**Redevelopment of St Anthony of Padua Catholic School  
125-165 Tenth Avenue and 140-170 Eleventh Avenue, Austral (SSD 8865)  
Notice of Exhibition**

## **TAB A – Comments on State Significant Development application (SSD 8865)**

TITLE				
ELEVENTH AND FOURTH AVENUE INTERSECTION				
SCALE AS SHOWN	DRAWN M.D.	DESIGNED M.D.	CHECKED L.S.	APPROVED M.C.
JOB No. 5914002		DRAWING No. SK-04		ISSUE 01
DATE SEPT. 2019		STATUS DEVELOPMENT APPLICATION

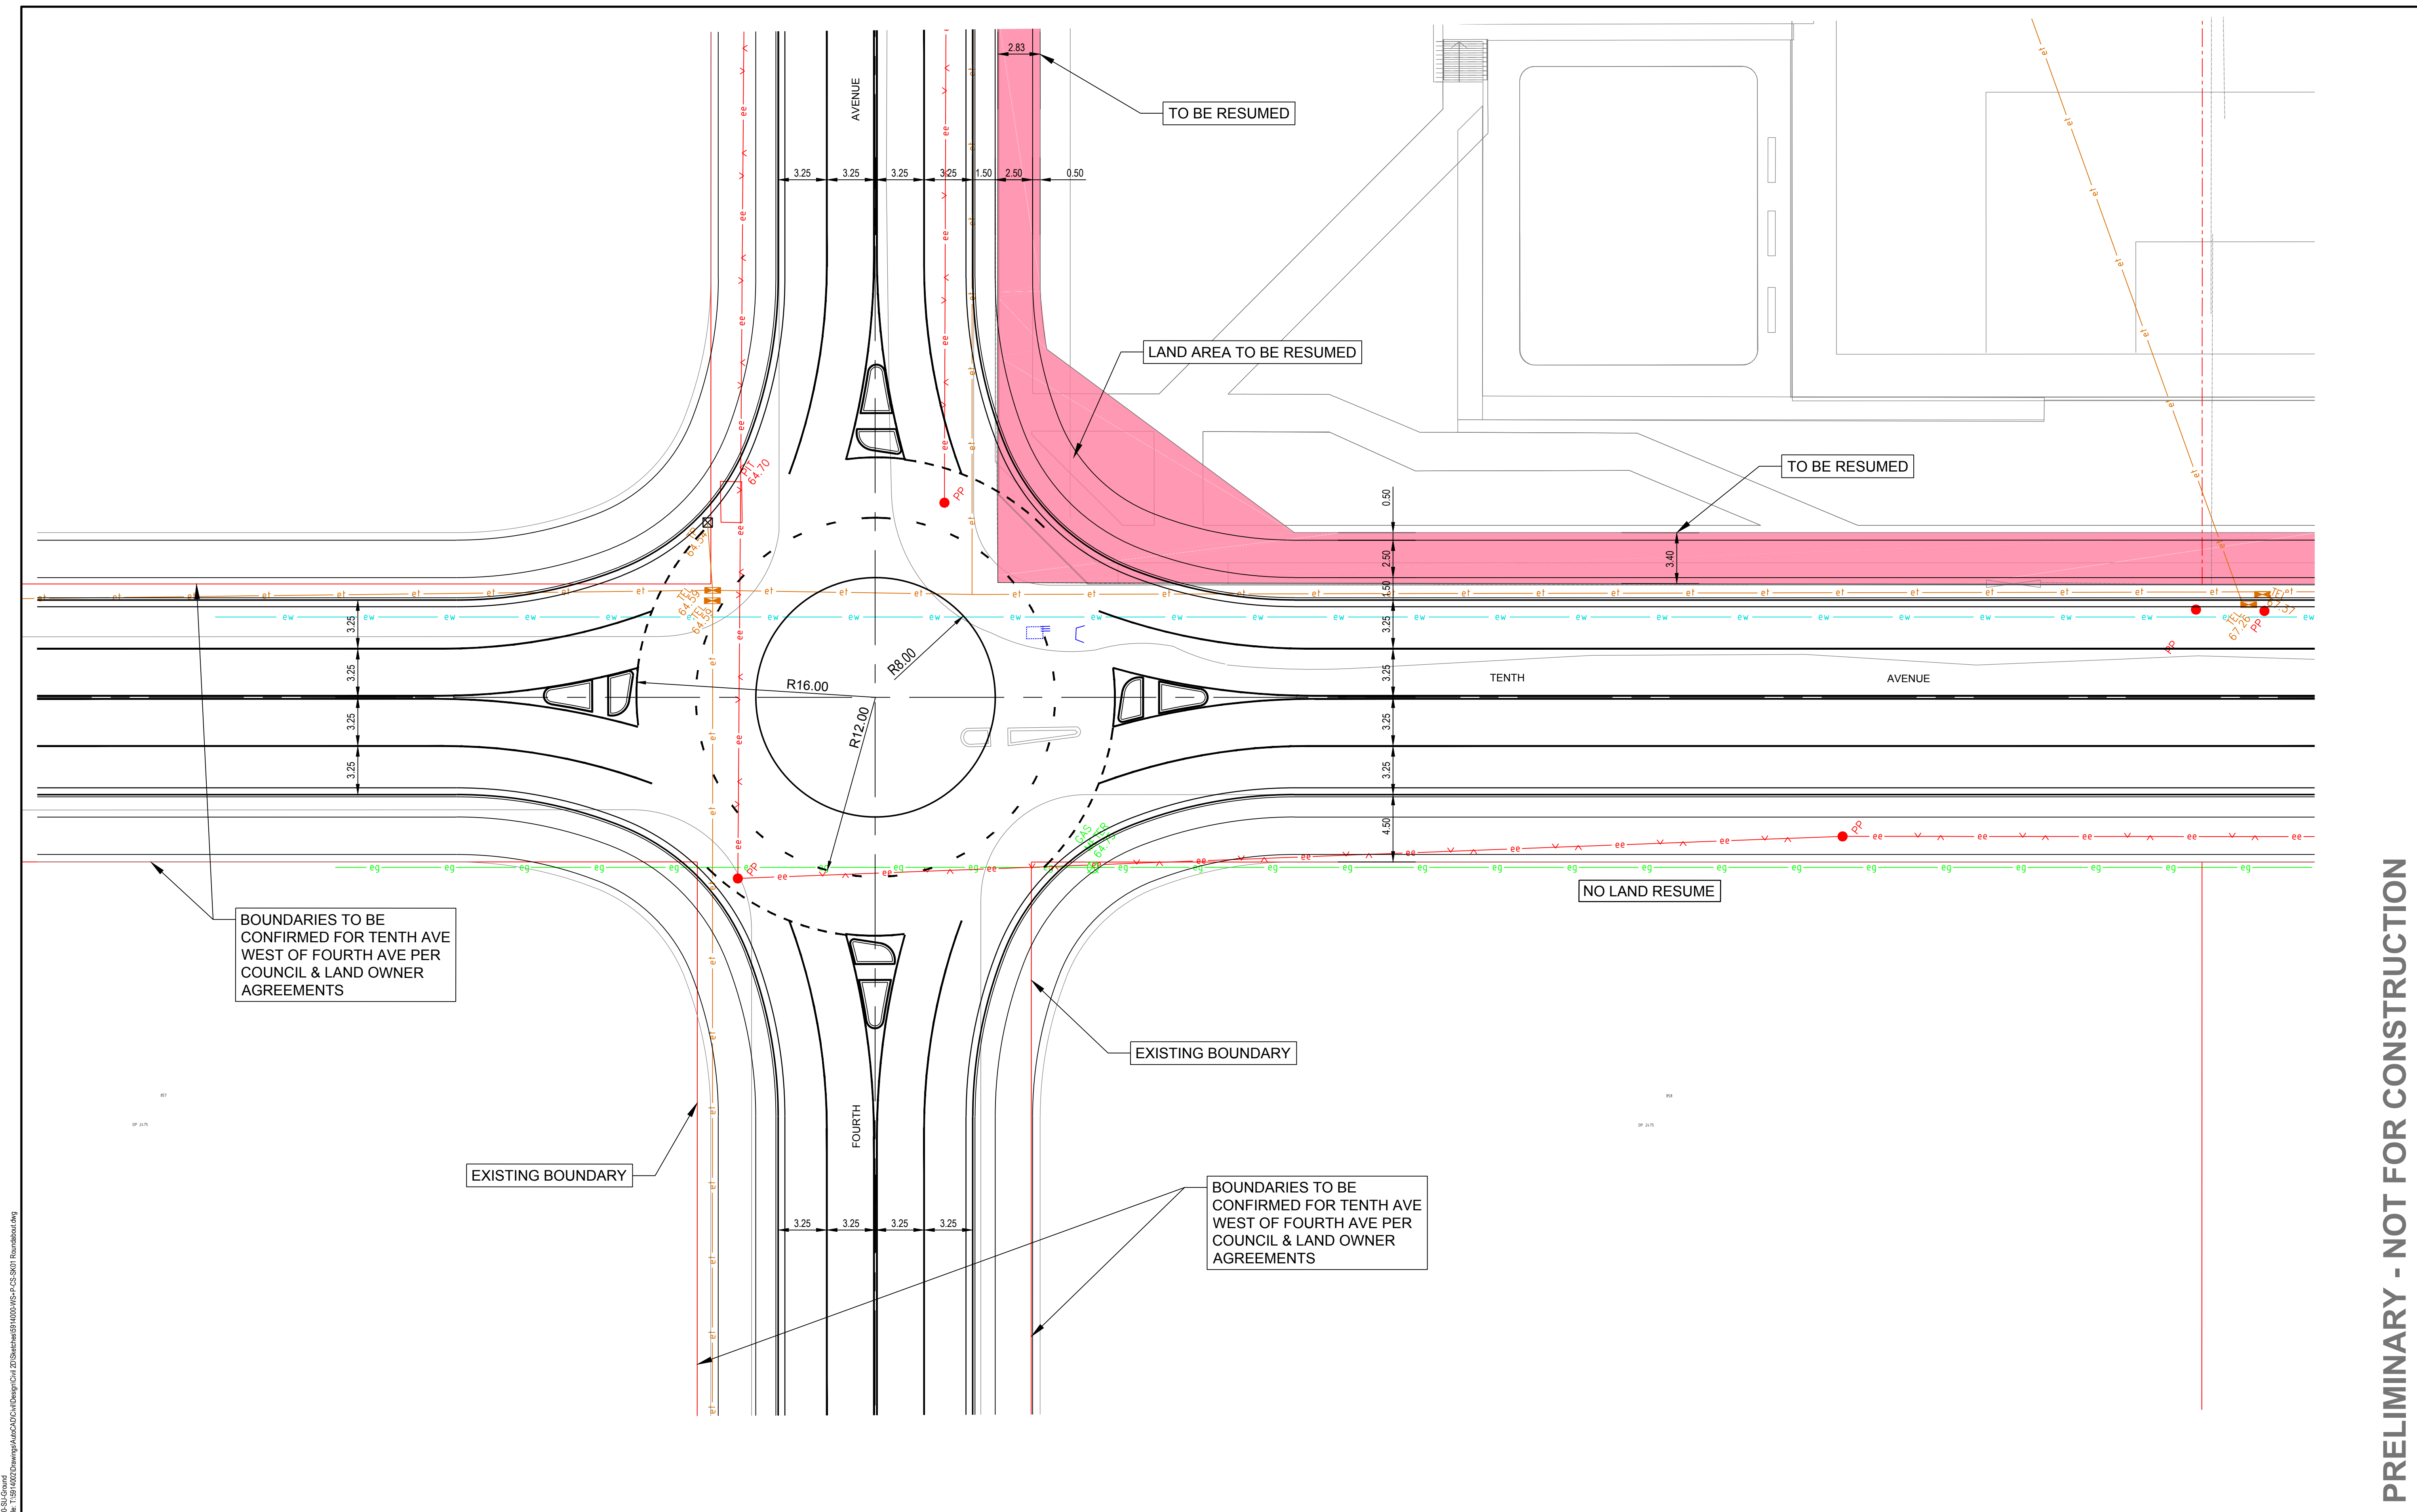
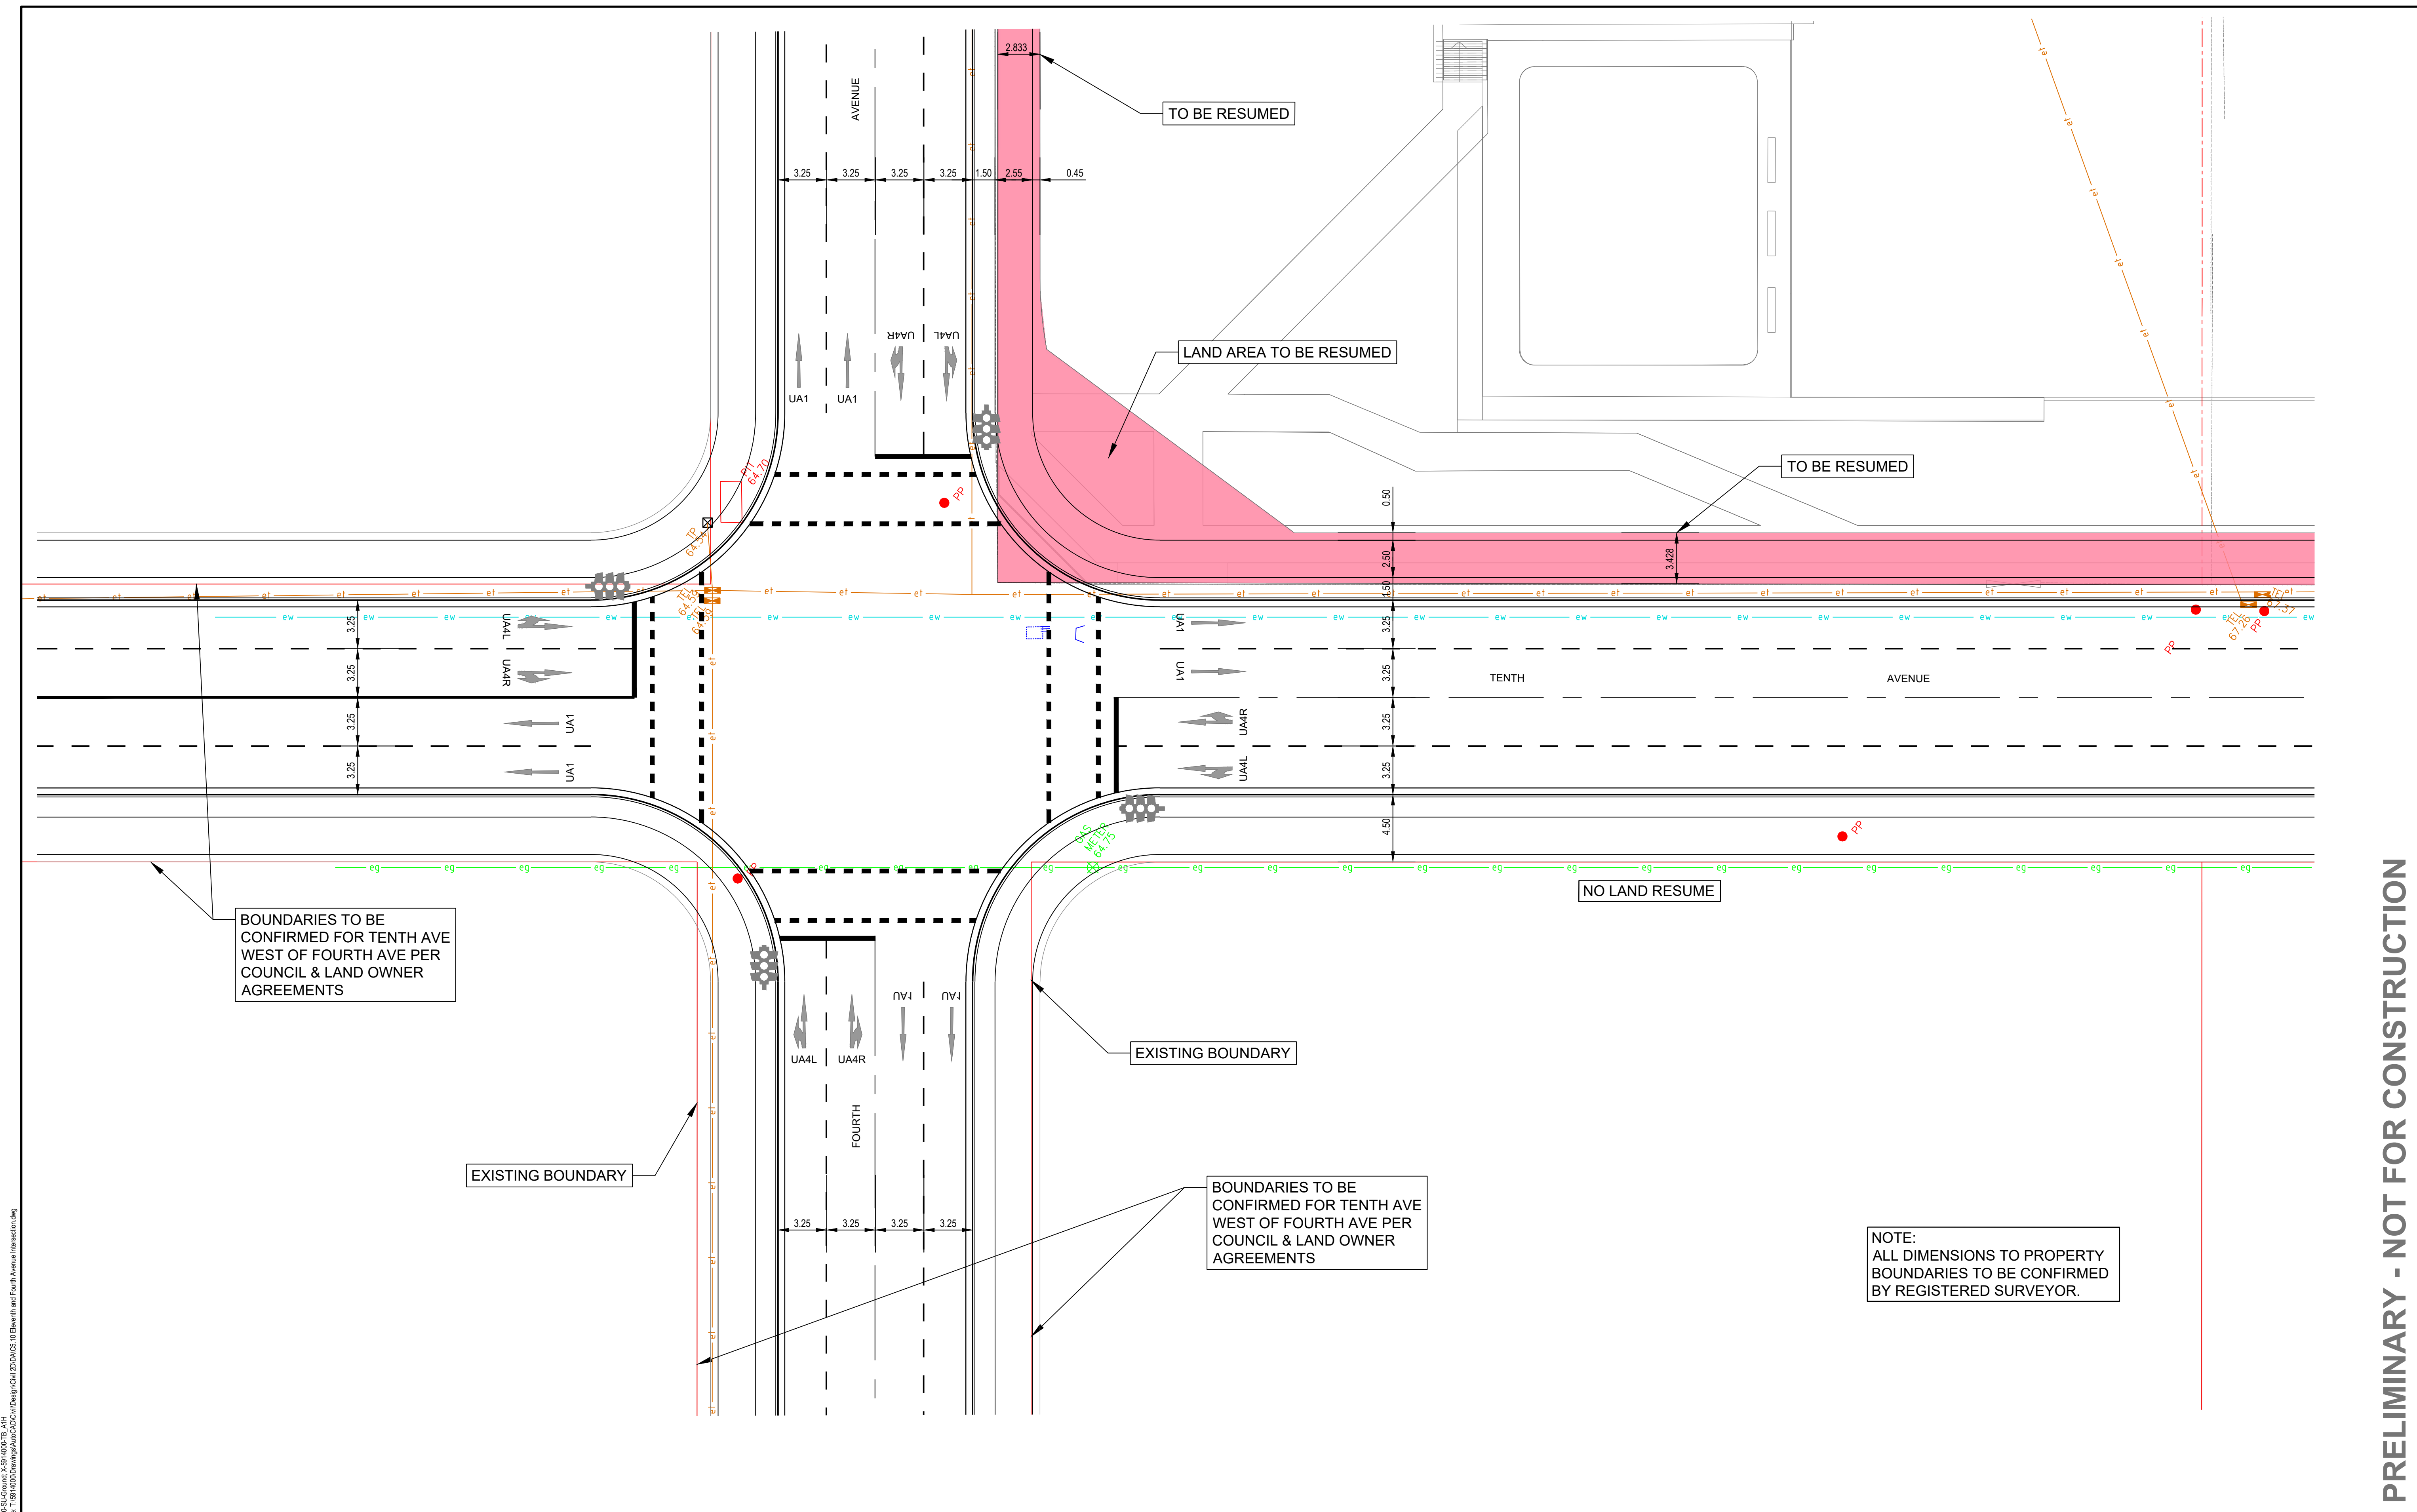
The Transport and Accessibility Impact Assessment report prepared by Colston Budd Rogers & Kafes Pty Ltd (October 2018) provides likely timeframes for the signalisation of the intersections at Fourth Avenue with Tenth Avenue and Edmondson Avenue with Eleventh Avenue. It is unclear within the traffic report of the justification of the proposed traffic signals, which are beyond that envisaged for the Austral & Leppington North precinct.

Furthermore, it is unclear whether the proposed timing of the signalisation of the aforementioned intersections is suitable having regard for the expected growth of the precinct.

Clarification should be provided regarding the justification for the proposed traffic signals and the timing for the delivery of the signals.
